Re: Forest Ridge Phase 2

Re: LPF-21-00006 Forest Ridge – Phase 2 PBCP
Re-submittal

I am providing you this letter and enclosed documents in response to your “Request for Additional Information” letter dated August 27th, 2021. Below is an itemized response to each of your comments completed by our office, Ed Sewall and the applicant.

DWN BY	DATE	JOB NO.
T.S.	09/2021	18069
CHKD BY	SCALE	SHEET
M.K.K./D.L.P.	N/A	1 OF 7

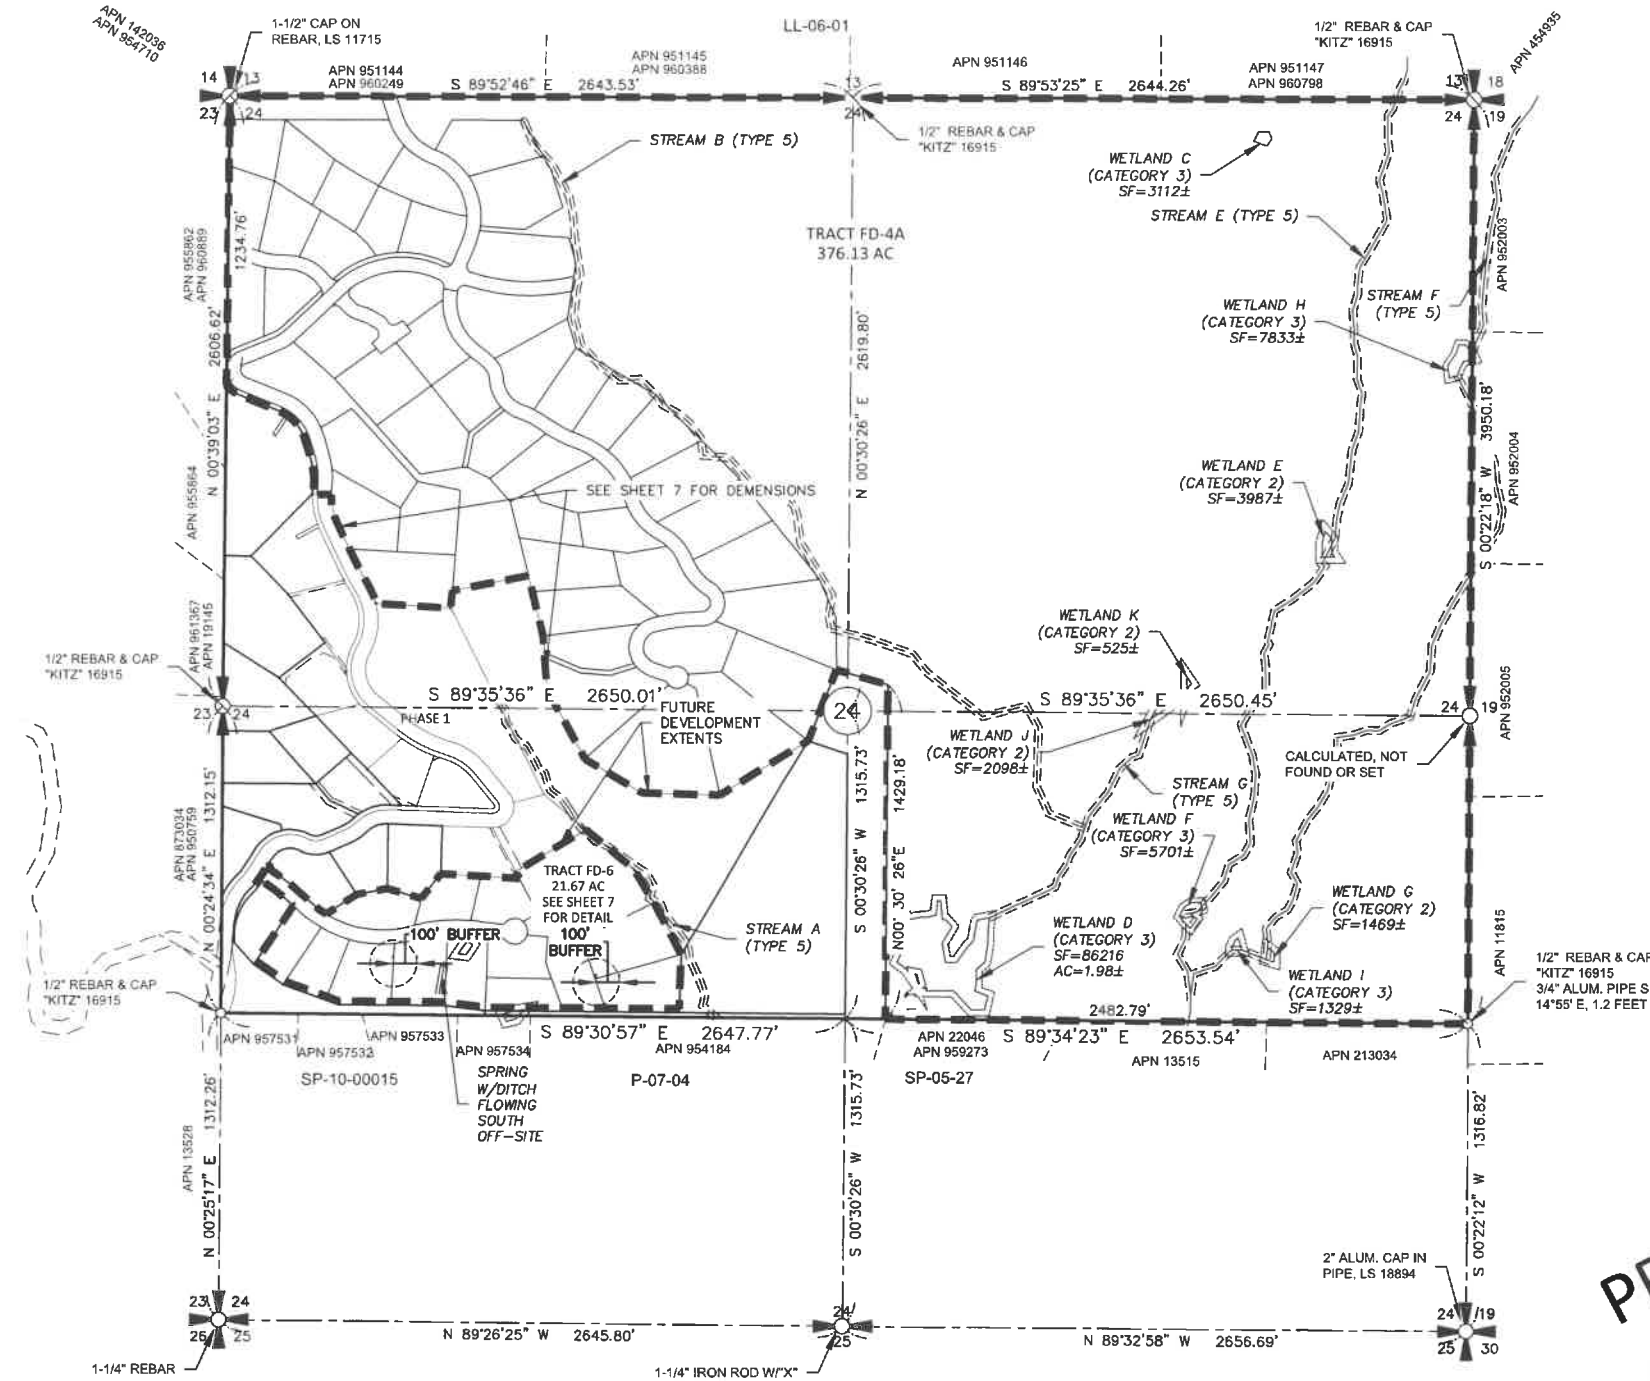
- Survey Sheet 1
 - Change CDS and Assessor approvals to reference “Forest Ridge-Phase II”. – **See enclosed survey map reflecting change.**
 - Update Existing KC parcel and map numbers prior to final recording. – **See enclosed survey map reflecting update.**
- Survey Sheet 3:
 - Tract FD-4 and Tract FD-6 are not dimensioned – **See enclosed survey map (Sheet 7) reflecting addition. Tract FD-4 has been revised to Tract FD-4A.**
- Survey Sheet 4:
